Huntlee Mod10 Response to Submissions

I write to you on behalf of Huntlee Pty Ltd in regard to the proposed S4.55 1A Modification Application (MOD 10) to Project Approval MP10_0137. The purpose of this letter is to provide a response to the Submissions prepared by Government Agencies, organisations and individuals. A summary of the comments raised in each submission and responses are provided in **Table 1** below.

STORMWATER MANAGEMENT
PLAN
GENERAL ARRANGEMENT

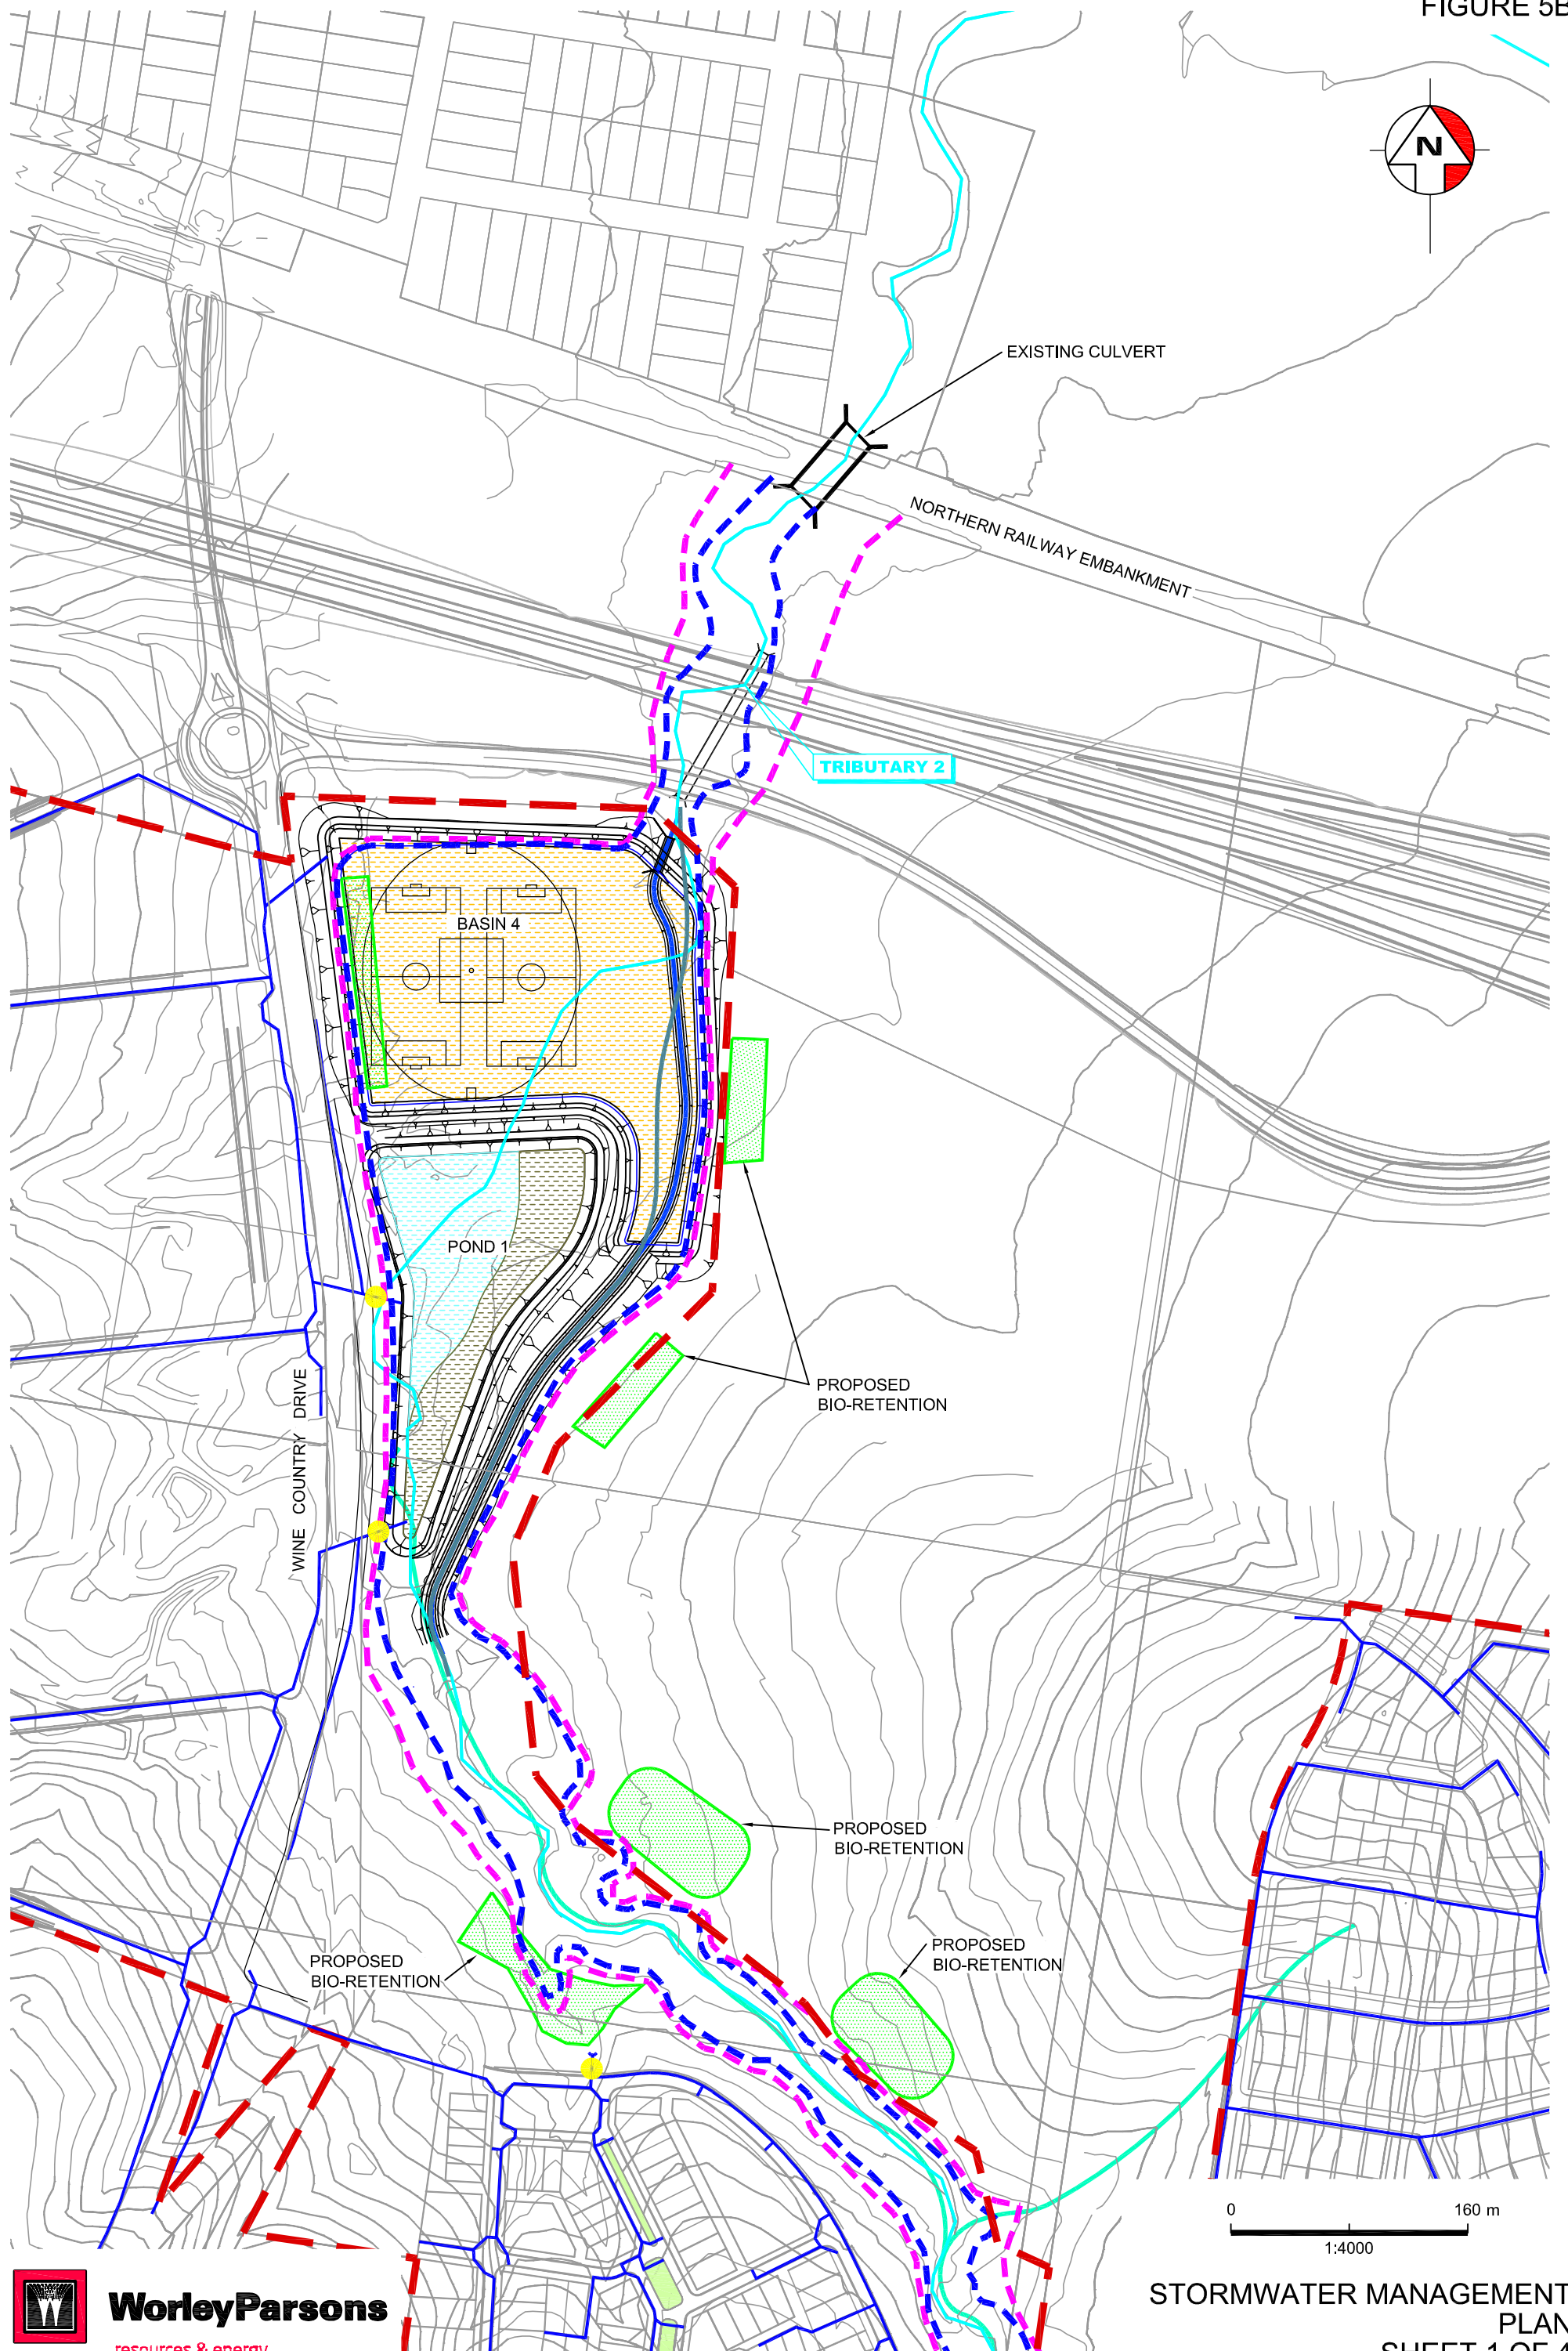
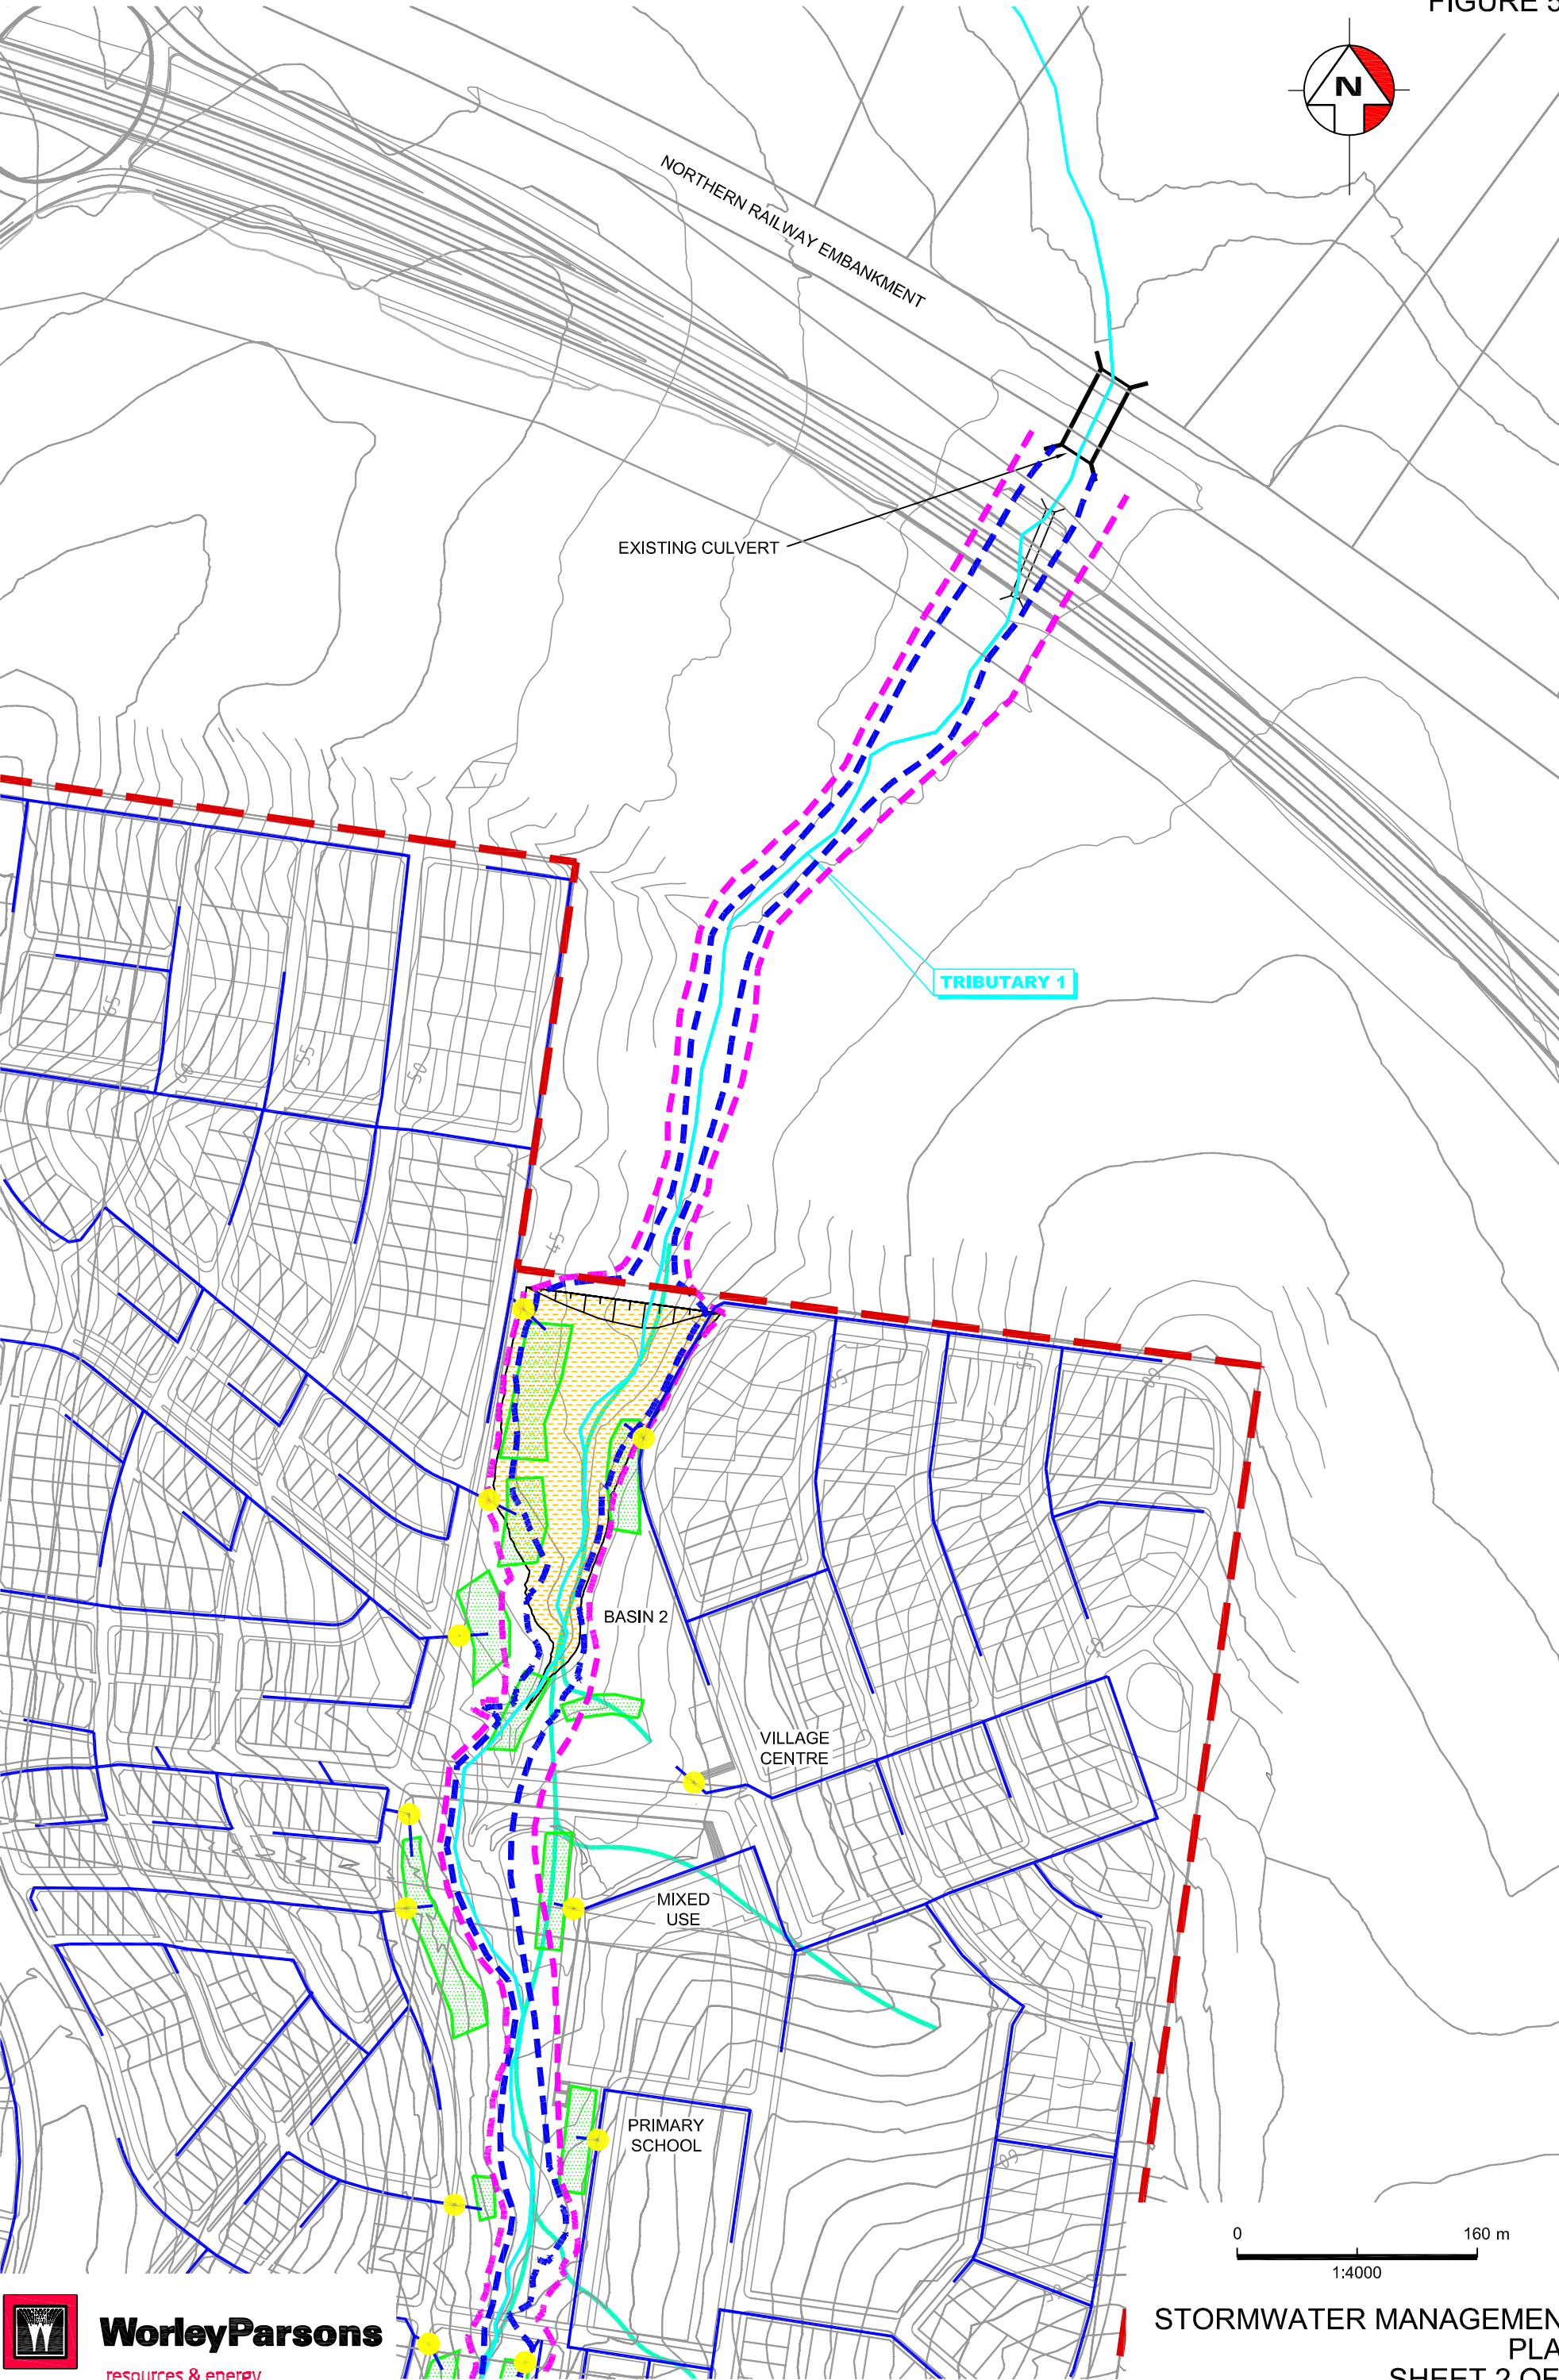
Cessnock Council	
The proposed stormwater detention basin in Substage 1 and Town Centre should not be identified as public open space. It presents a risk to the public and is not usable. Further it will have implications on the approval pathway due to Huntlee's Planning Agreement with Council.	Currently the VPA does not contain any other definition which can be used to identify general detention/water quality structures rather than General Public Open Space. The approved stormwater management plans include many stormwater management structures within riparian corridors and public open space within the development. Regardless of the definition, the areas will be handed over to Council and so inclusion within the VPA ensures Council has an ability to track the area and dedication of these assets. Should Council wish to amend the VPA to identify these separately or have them removed from the VPA, Huntlee P/L is prepared to negotiate an amendment to the VPA prior to the dedication of the stormwater management structures that are the subject of this modification.
